# CITY OF ALBUQUERQUE

**Re: McDonalds 1600 Alameda NW, Grading and Drainage Plan**  
**Engineer's Stamp dated 8-28-06 (B14/D14)**

5 REFUSE ENCLOSURE
Scale: 1/8" = 1'-0"

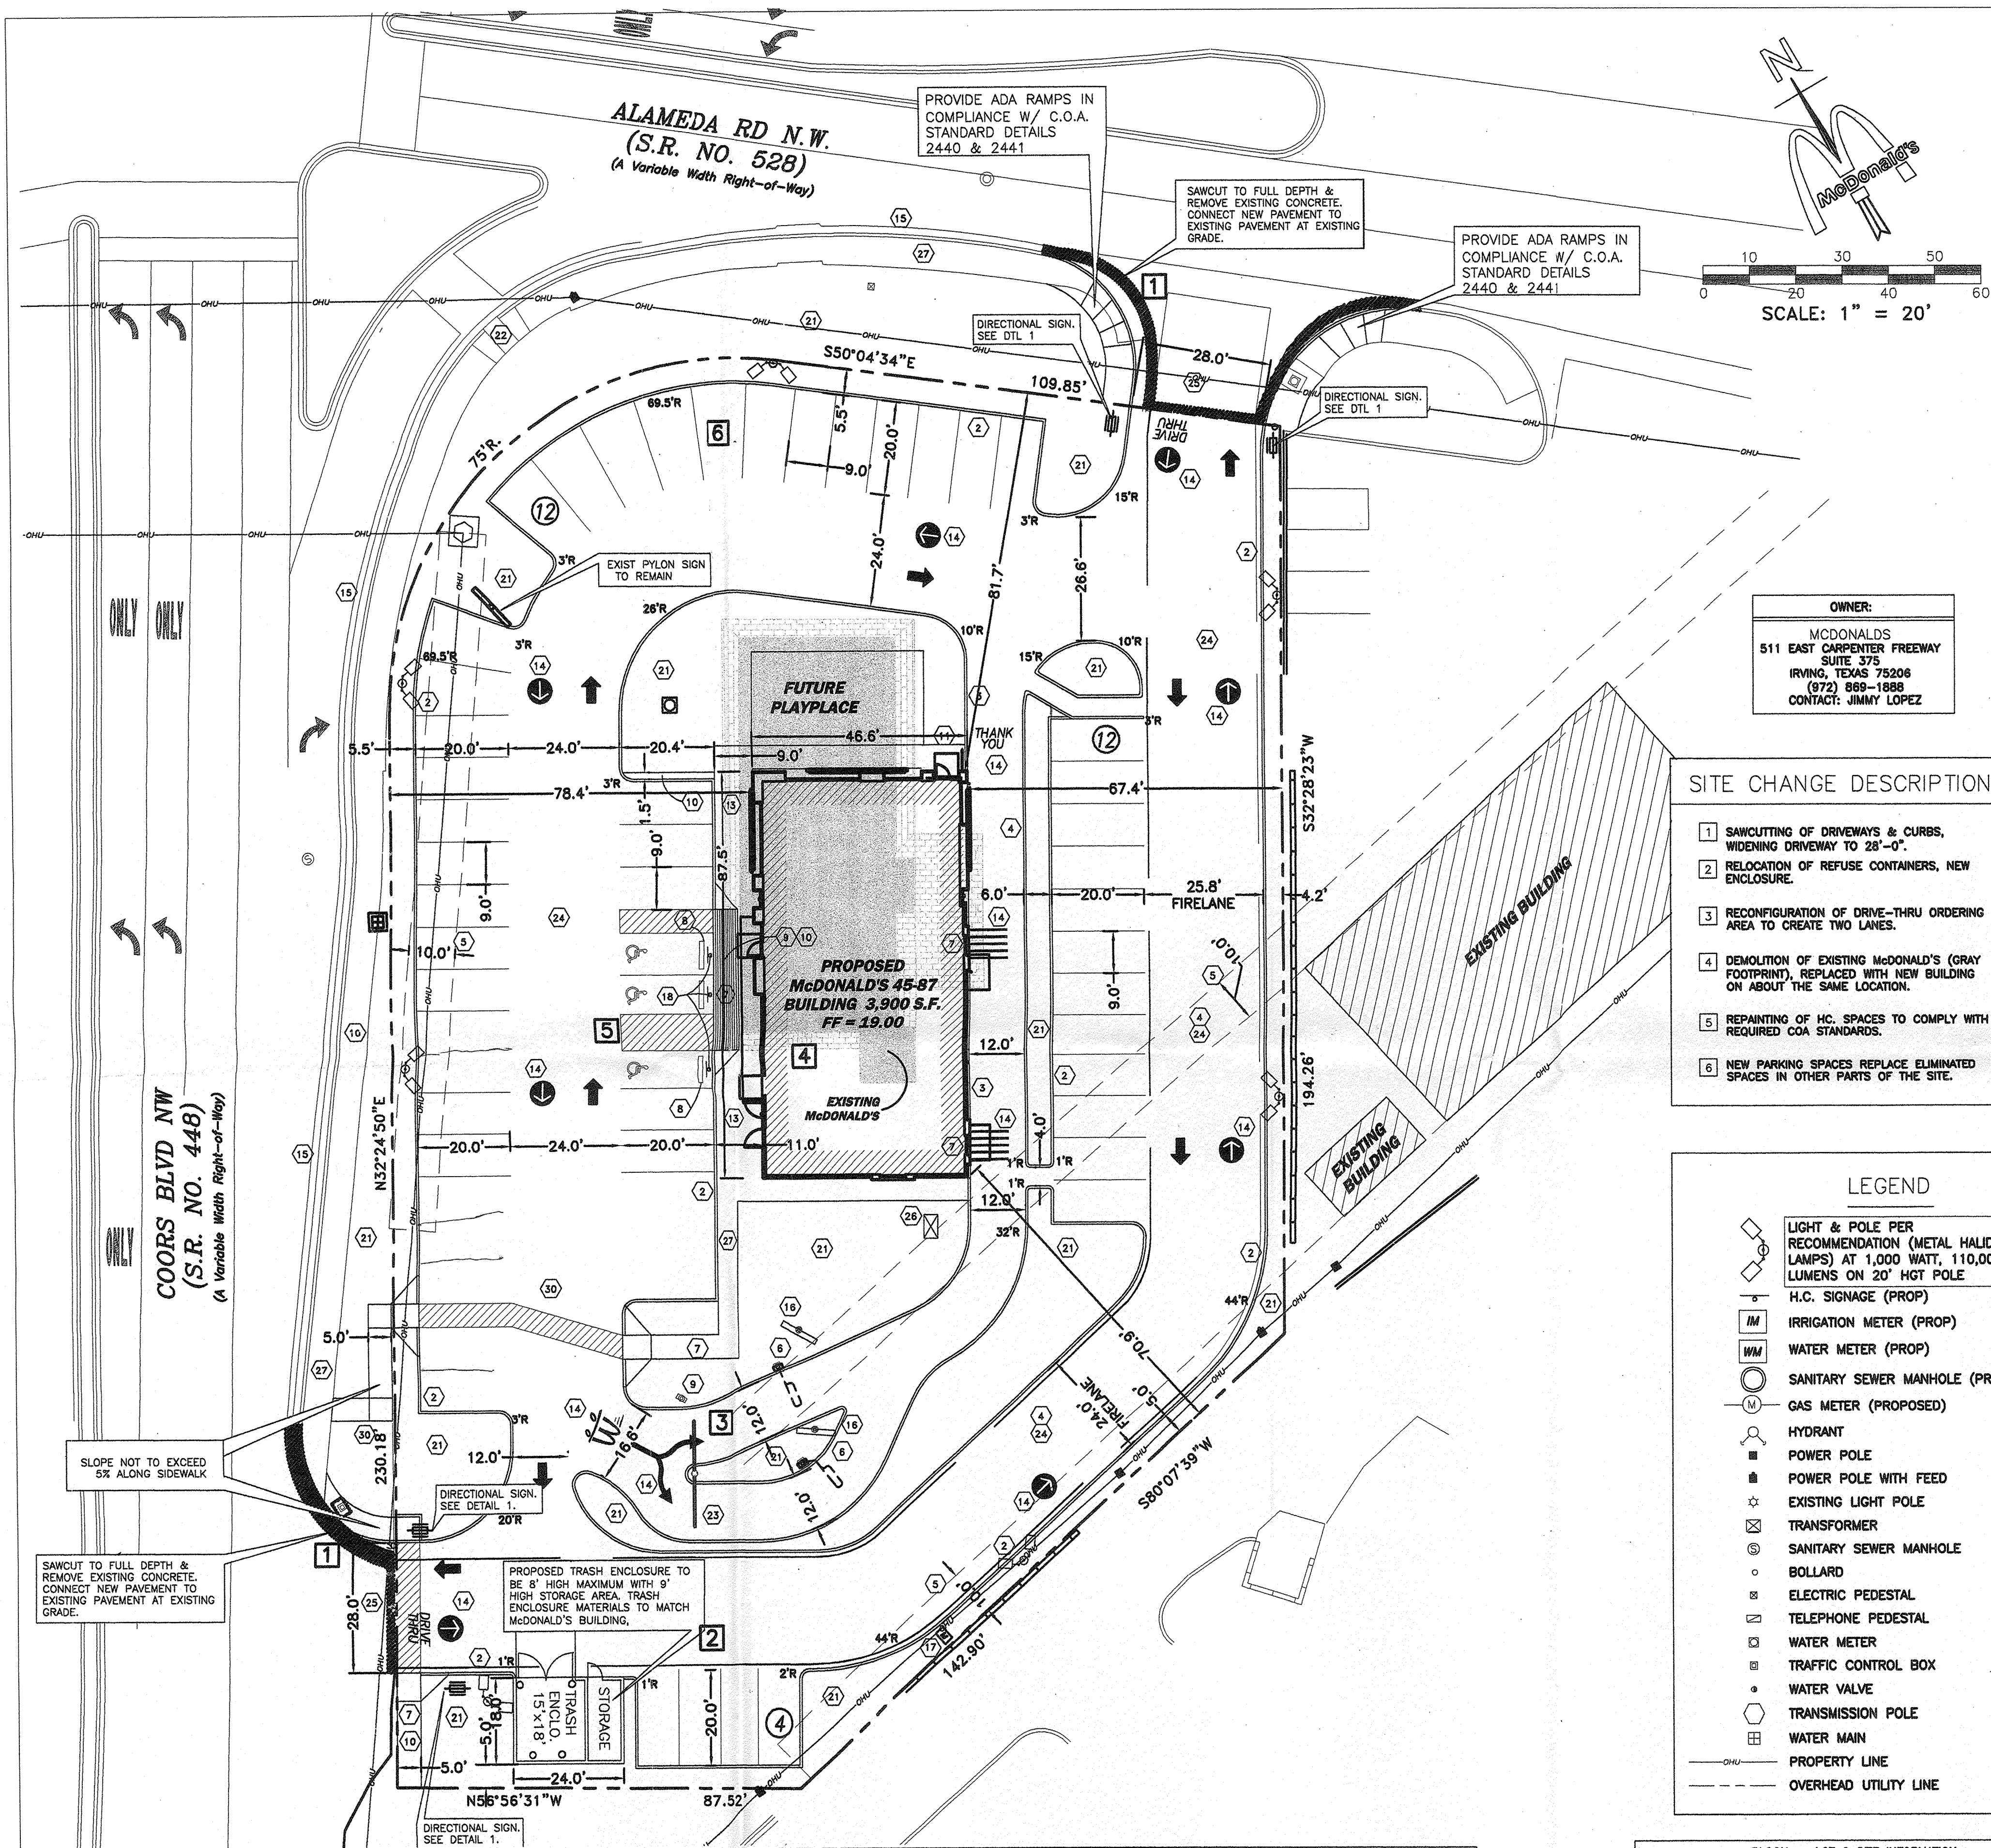
- Add a drain to the trash enclosure. Drainage from trash enclosures is required to be conveyed to the sanitary sewer.
- Engineer Certification per the DPM checklist will be required.
